PRE-HEARING STAFF ANALYSIS

Rezoning Petition No. 2005 - 108

Request: R-4, single-family to R-8MF(CD), multi-family conditional district.

SITE PLAN

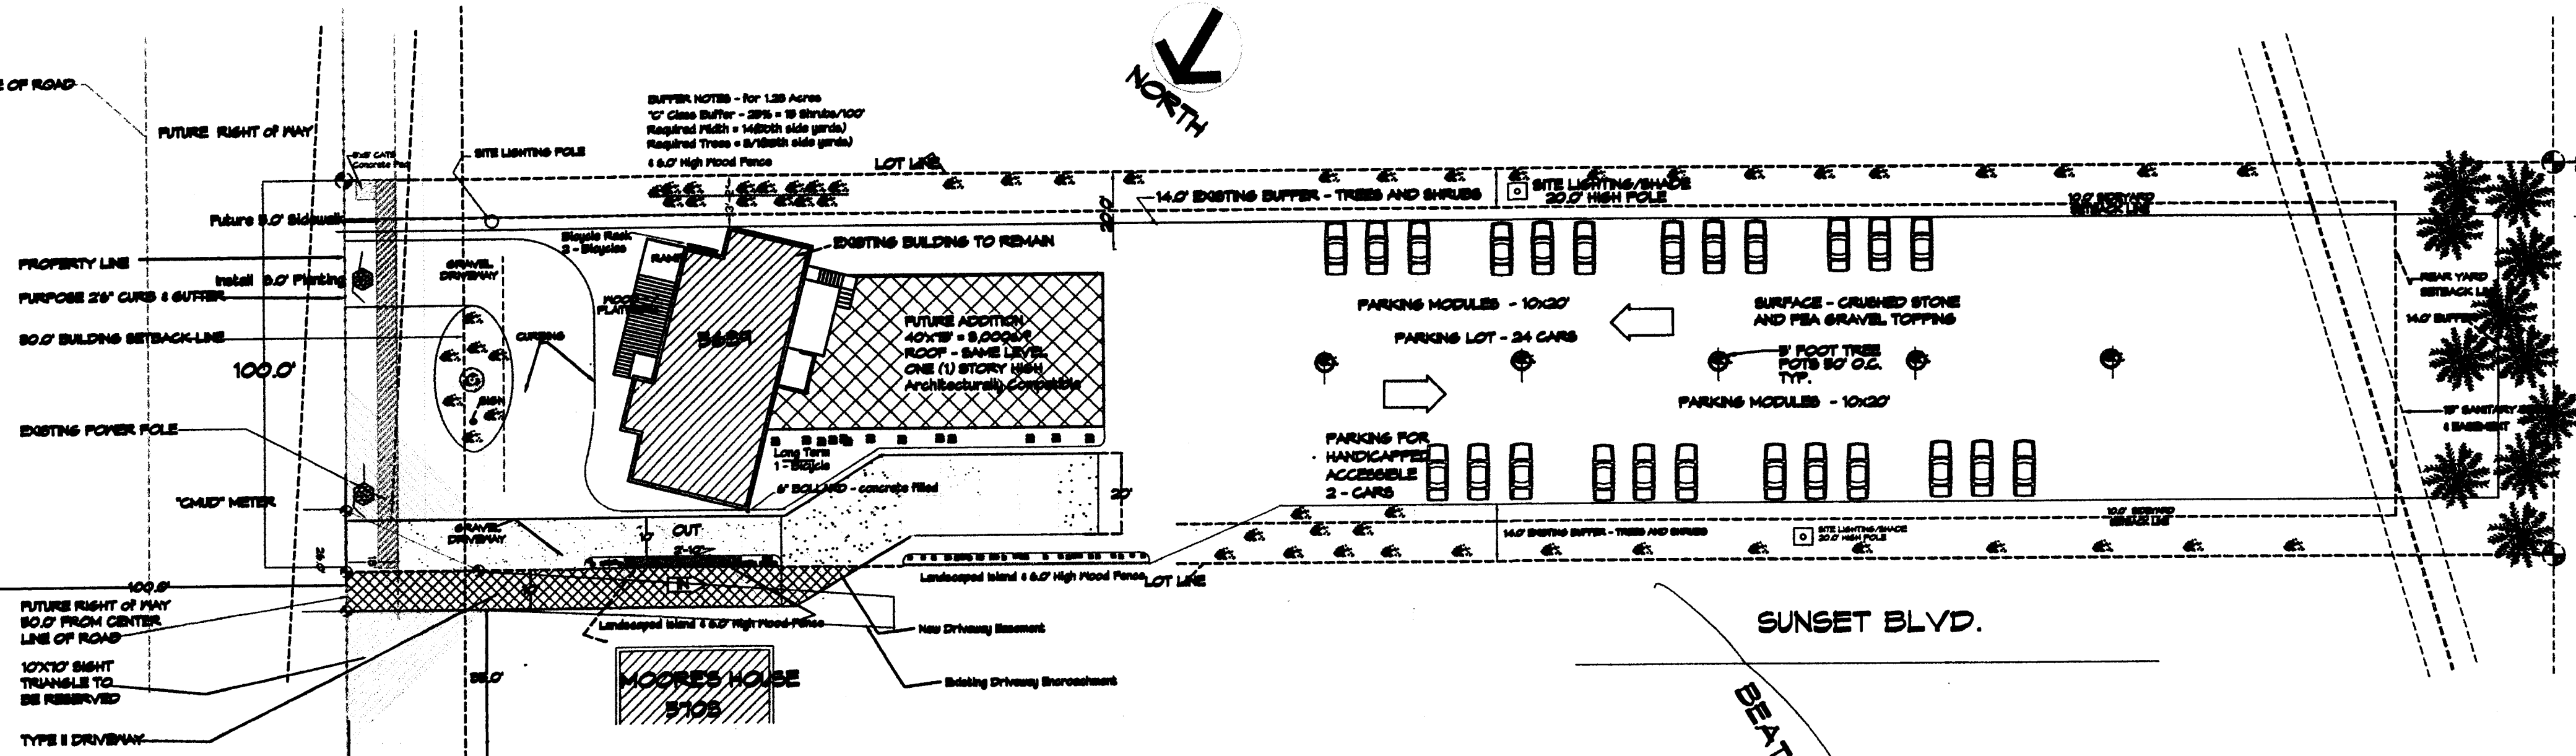
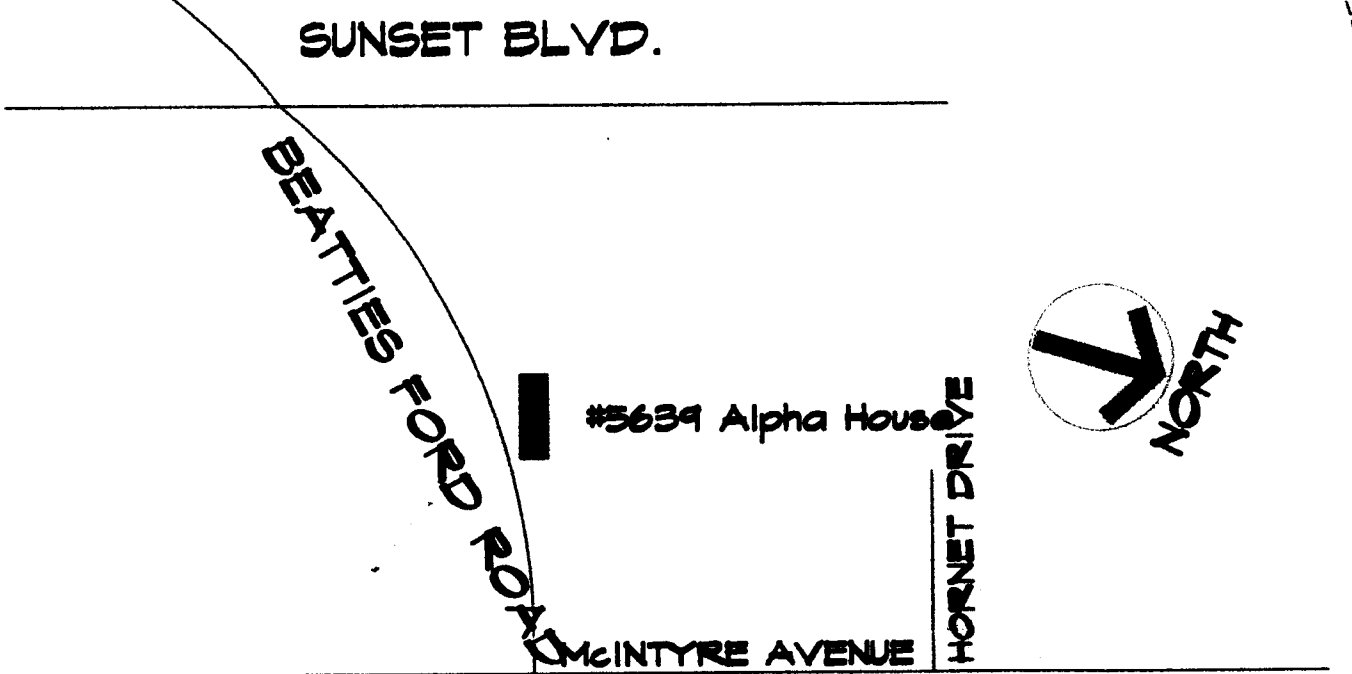
- The site plan should show the future right-of-way line and the setback line from the new right-of-way.
- The petitioner should remove the parking between the building and the street.

- The petitioner should correct the petition number on the site plan.
- A reduced buffer should be shown along the southern property line.
- The buffer width should be shown along the western property line.

- The cross-section for the buffer along the driveway should be corrected to reflect the variance.
- The required landscaping in the parking lot should be shown.

- CATS comments should be addressed.
- The plan should note that the petitioner will install the five foot sidewalk and eight foot planting strip along Beatties Ford Road.

- A note should be added to the plan indicating that the existing structure will remain and the future addition will be architecturally compatible.
- The plan should include a note that lighting will not exceed twenty feet in height and that it will be fully shielded and capped with no wall “pak” lighting allowed.

- The future 3,000 square foot expansion should be noted in the site data.
